**RE: Cloverleaf Filing No. 2 - Plat**

The Woodmoor Water and Sanitation District No. 1 (the District) has received the plat related to the Cloverleaf Filing No. 2 and currently had the following concerns and/or recommendations:

JOB NO. 25158.01
MAY 7, 2021
SHEET 2 OF 7

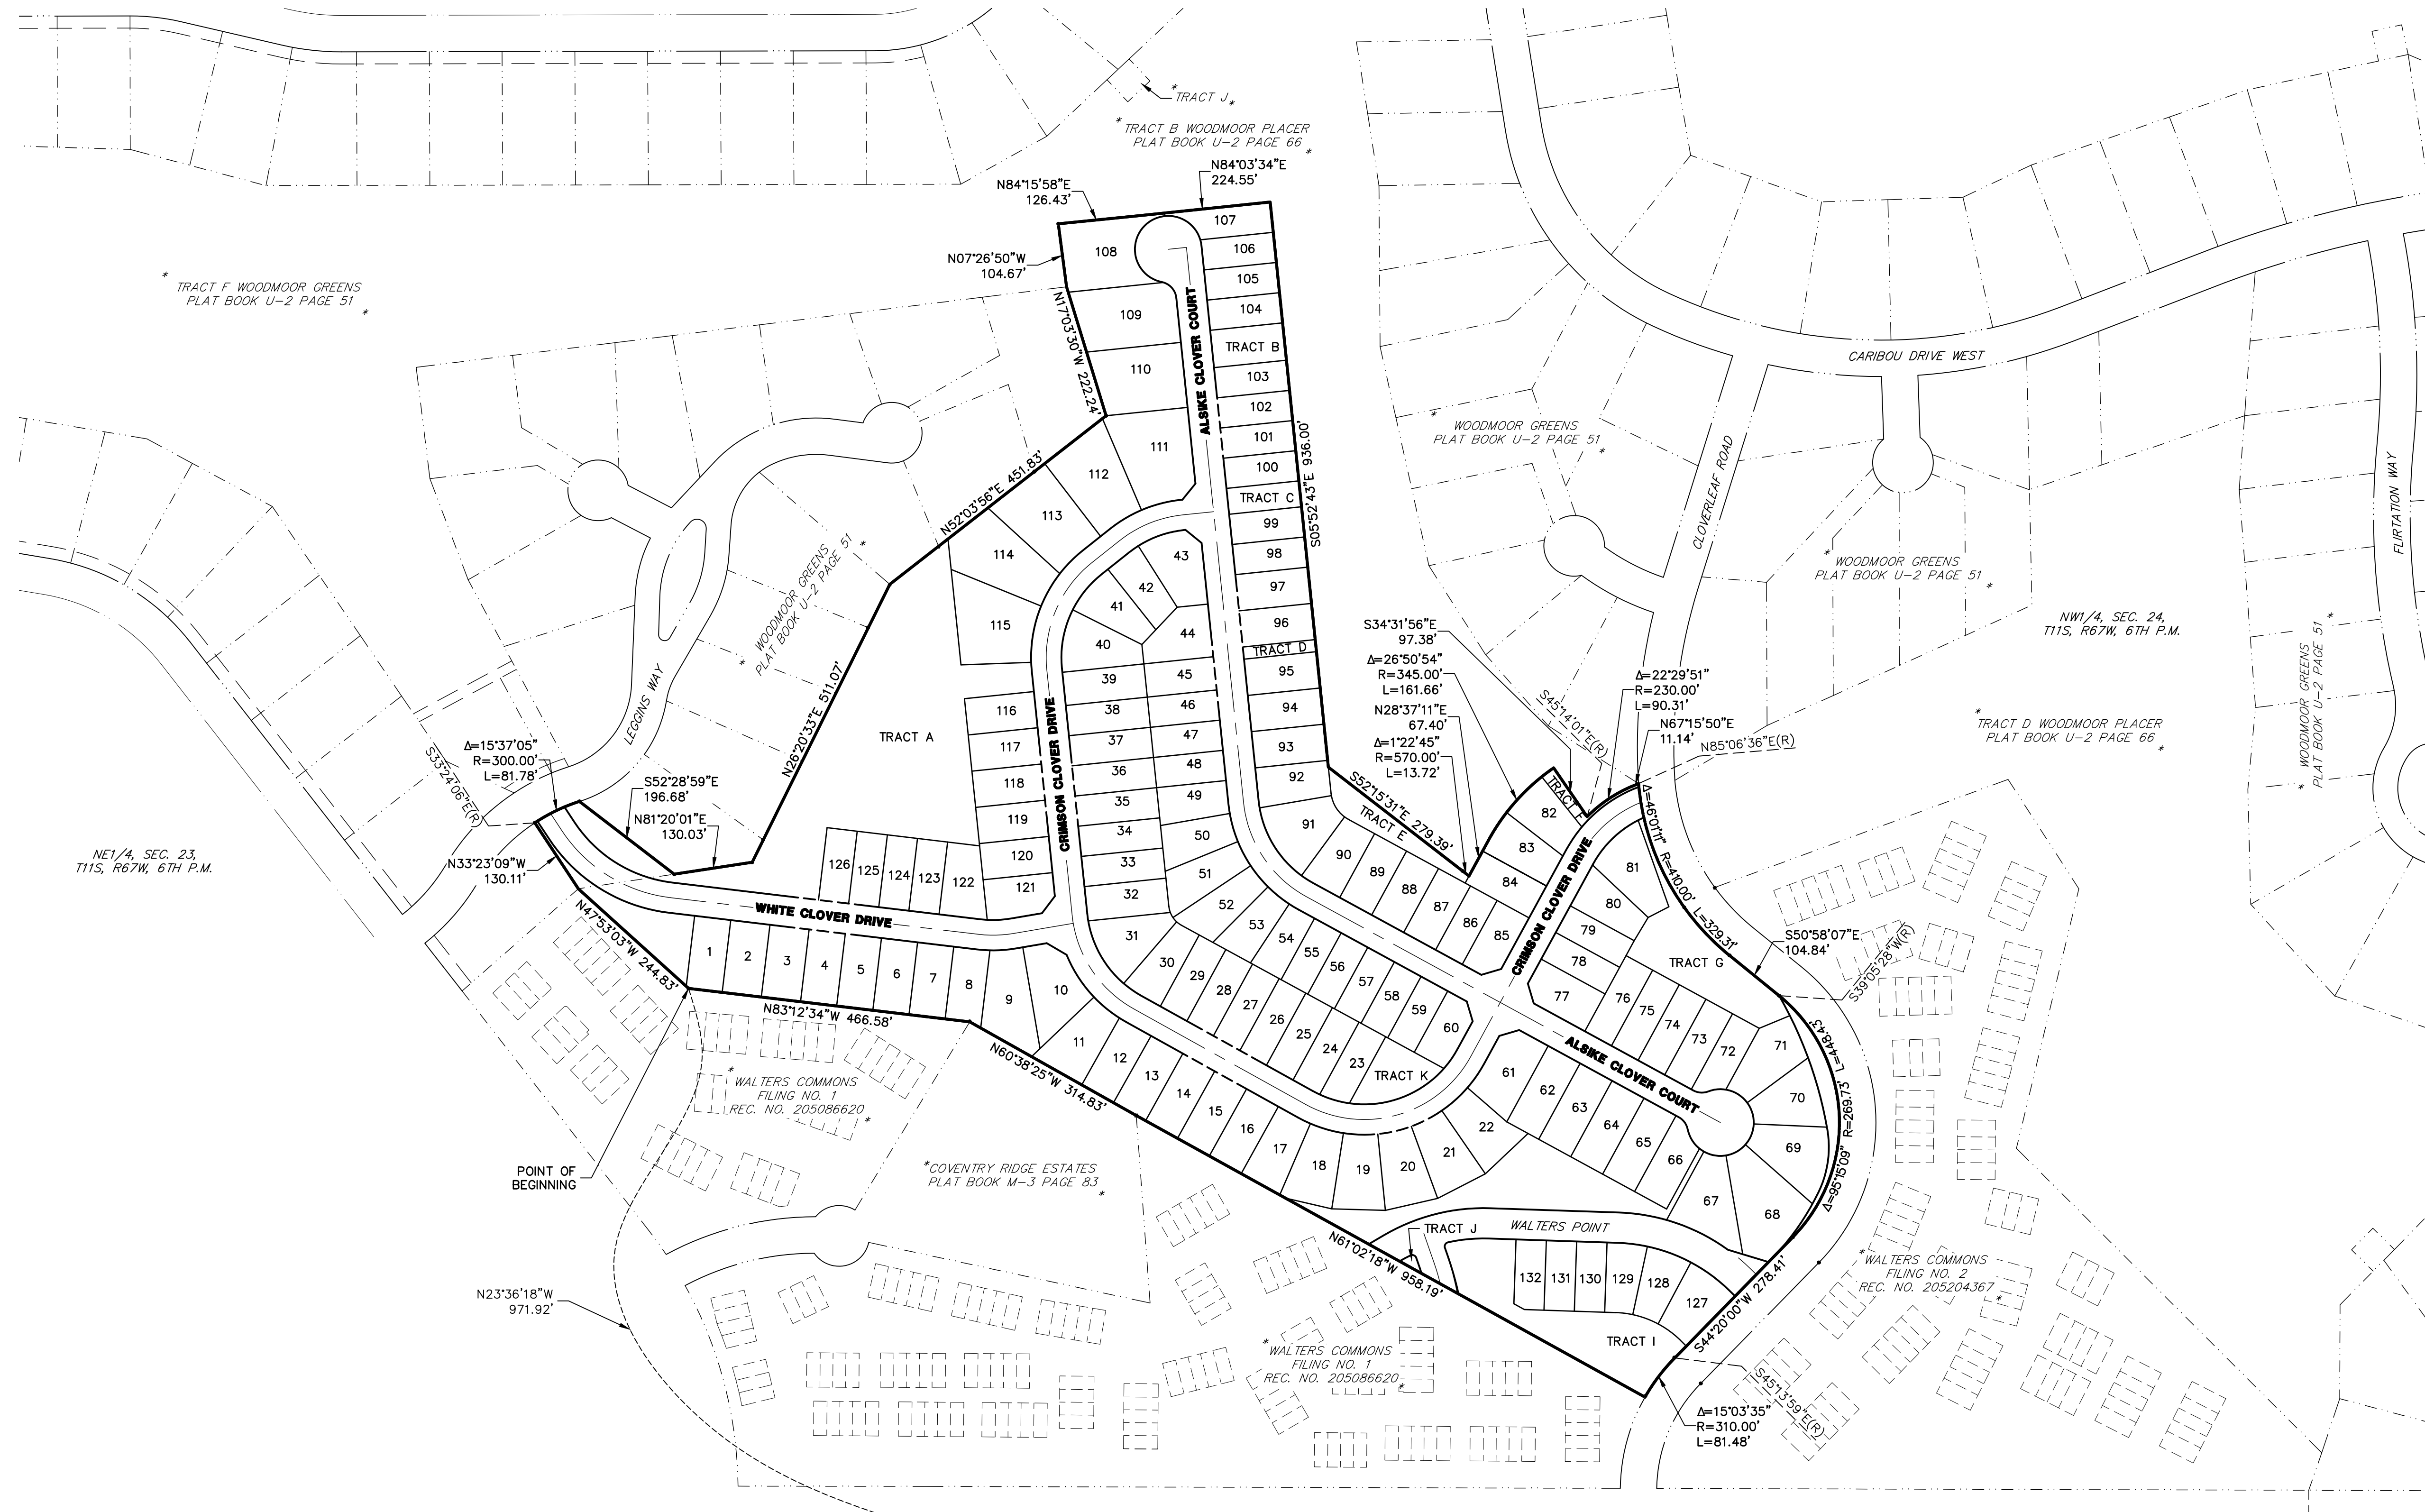
1. In the General Notes, #11 should read “WATER AND SANITARY **SEWER** SERVICES SHALL BE SUPPLIED BY WOODMOOR WATER AND SANITATION DISTRICT No. 1”
2. On Sheet 3 of 8, Tract L is not labeled.
3. On sheet 4 of 8, please replace “DRAINAGE” with “UTILITY” on the easement running through and to the east of Tract B, and add “See Detail A, Sheet 8” to description.
4. On sheet 4 of 8, please correct “D.E.” to “U.E.” in the easement description located in Tract B.
5. On sheet 6 of 8, “Tract” is misspelled on Tract H.
6. On sheet 7 of 8, please label the 20’ width of the easement in Detail A.
